Arun District Council
Arun Civic Centre
Maltravers Road
Littlehampton
West Sussex BN17 5LF
Planning & Building Control General Enquiries
Tel: (01903) 737756 Fax: (01903) 730442
Dx: 57406 Littlehampton
Minicom: 01903 732765
e-mail: planning@arun.gov.uk
website: www.arun.gov.uk/planning

17th November 2020

Application No: Y/106/20/PL
Site Address: Land to the south of Ford Lane East of North End Road Yapton BN18 0DS
Description of works: Construction of 3 dwellings as temporary sales area & sales office including access, parking and landscaping. This application affects a Public Right of Way.

FIG i) SALES ARENA

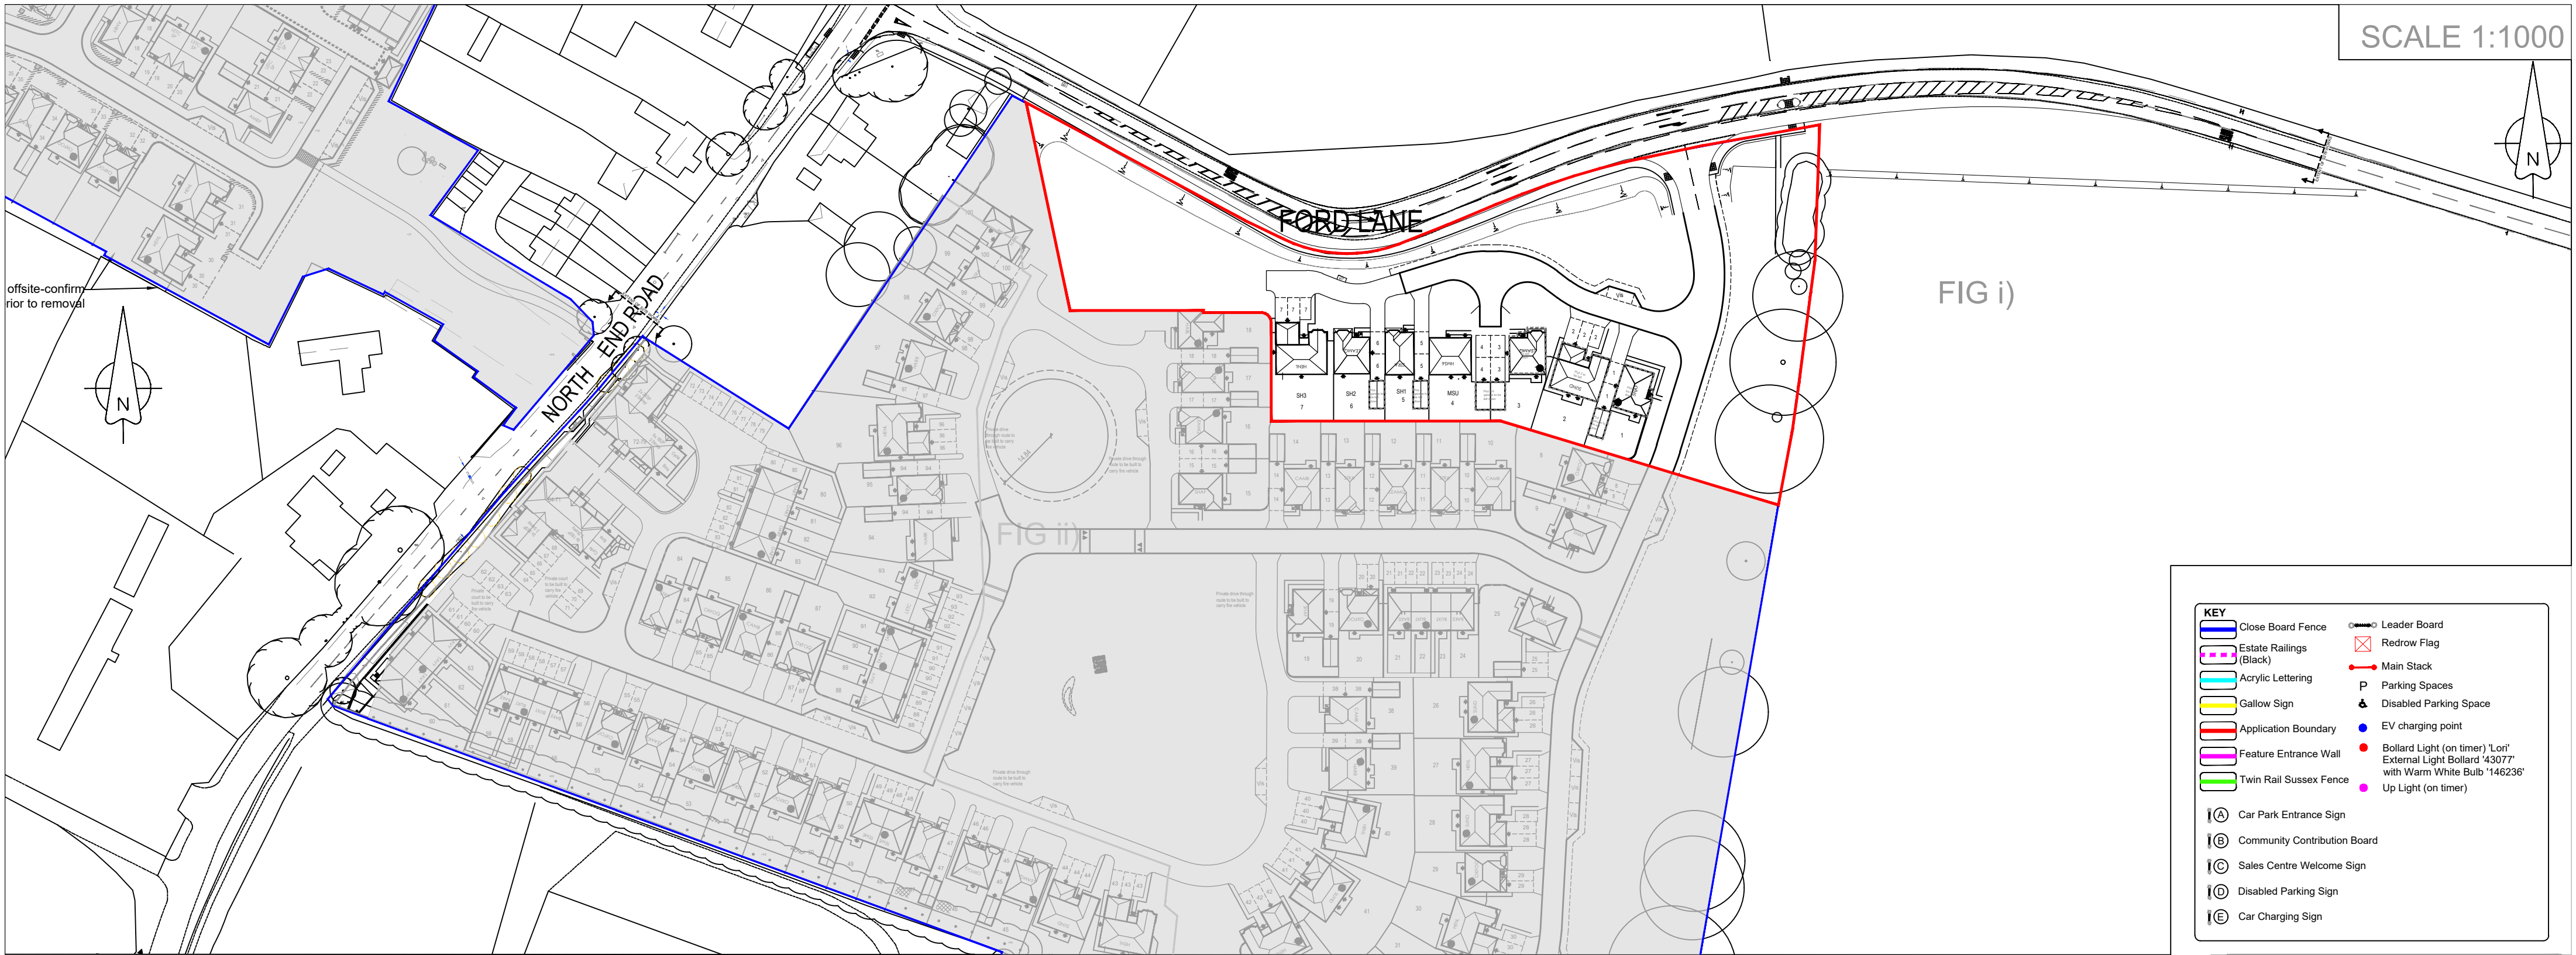
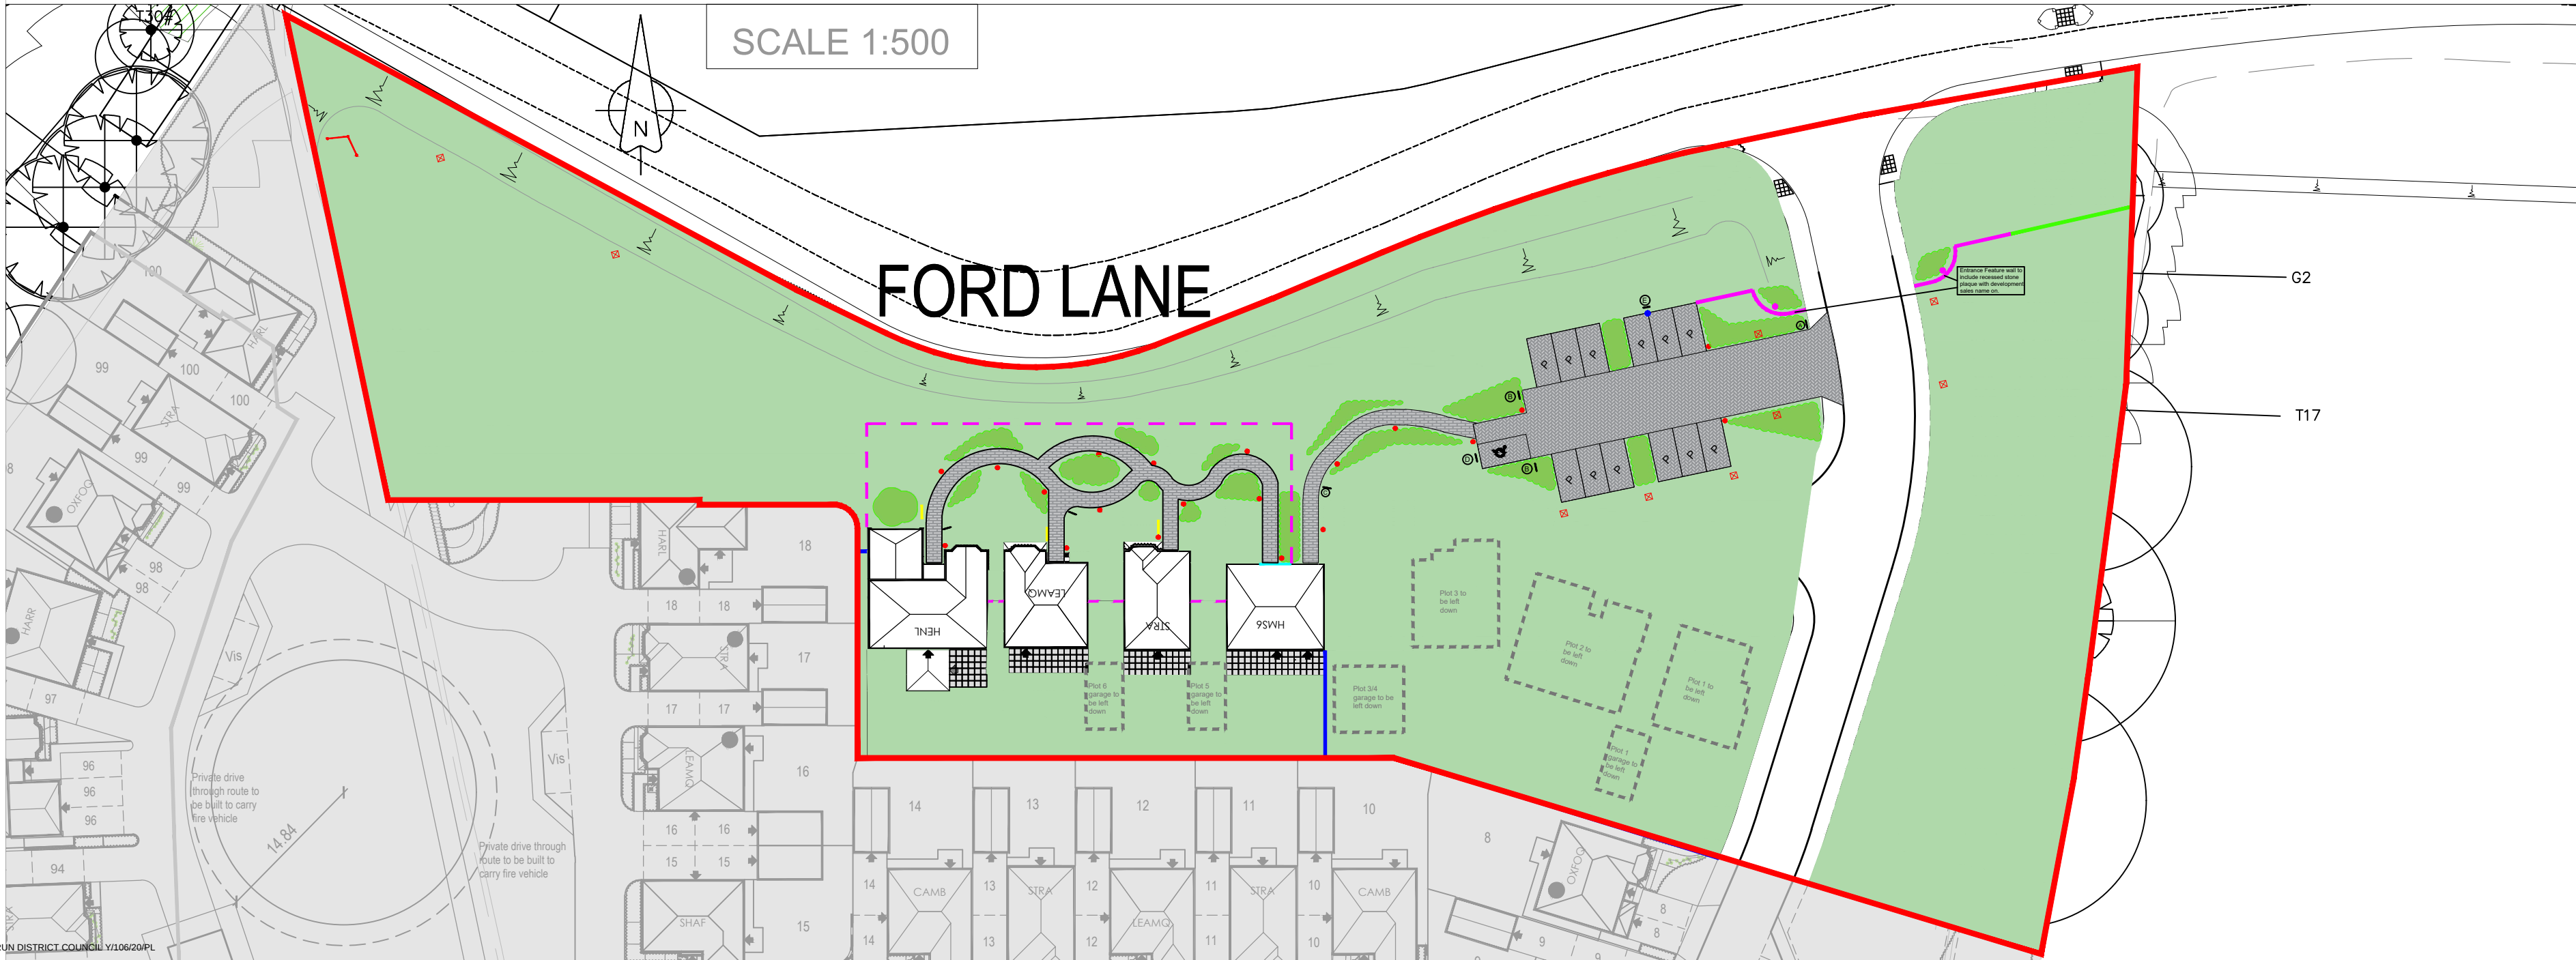
YPC has given due consideration to this application and would wish to ensure that all highways and access to the site have been completed prior to commencement of any building works of the temporary units.

YPC support the construction of the temporary dwellings conditional to them being converted to permanent dwellings on completion of the whole scheme. YPC would also expect a fully functioning and constructed vehicular access way built prior to members of the public being allowed on site to access the marketing suit and temporary dwellings.

YPC also note that the proposal has 20 low level illuminated bollards. YPC whilst recognising the need for pathways to be lit during show room trading hours insist that all bollards must be switched off out of trading hours to maintain the rural feel of Ford Lane.
